Environmental Health Consultation Response

To	Harry Chalk
Date	11-04-2026
Planning Ref	FG/14/26/DOC
Site Description	58 Ferring Street Ferring Worthing West Sussex BN12 5JP
Date of Application	2026-02-27 00:00:00
Category	
Recommendation	No Objection No Objection — with conditions Objection Holding Objection

From: chris.white@arun.gov.uk <chris.white@arun.gov.uk>
Sent: 11 April 2026 11:43
To: Planning.Responses <Planning.Responses@arun.gov.uk>
Cc: Chris White <Chris.White@arun.gov.uk>
Subject: Planning Response FG-14-26-DOC - 58 Ferring Street, Ferring, Worthing, West Sussex, BN12 5JP

SUZ-M71VAR1.TH
SUZ-M71VA-ET.TH
SUZ-M71VA-ETR1.TH

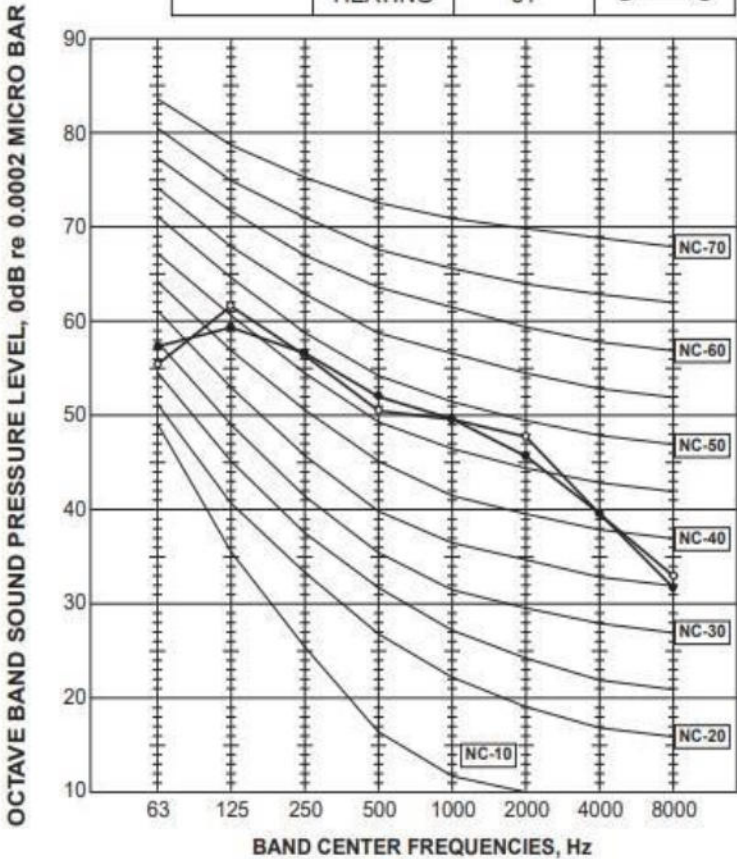
The submitted graph shows the NC curves which is the American standard not the required NR curve as set out in condition 3. The levels in the graph show the unit as operating over the NC45 curve with no assessment of what the level will be at the nearest noise sensitive property. The data graph also shows the levels undertaken in lab conditions not in situ, so does not take into account any reflected sound as would present in the proposed position.
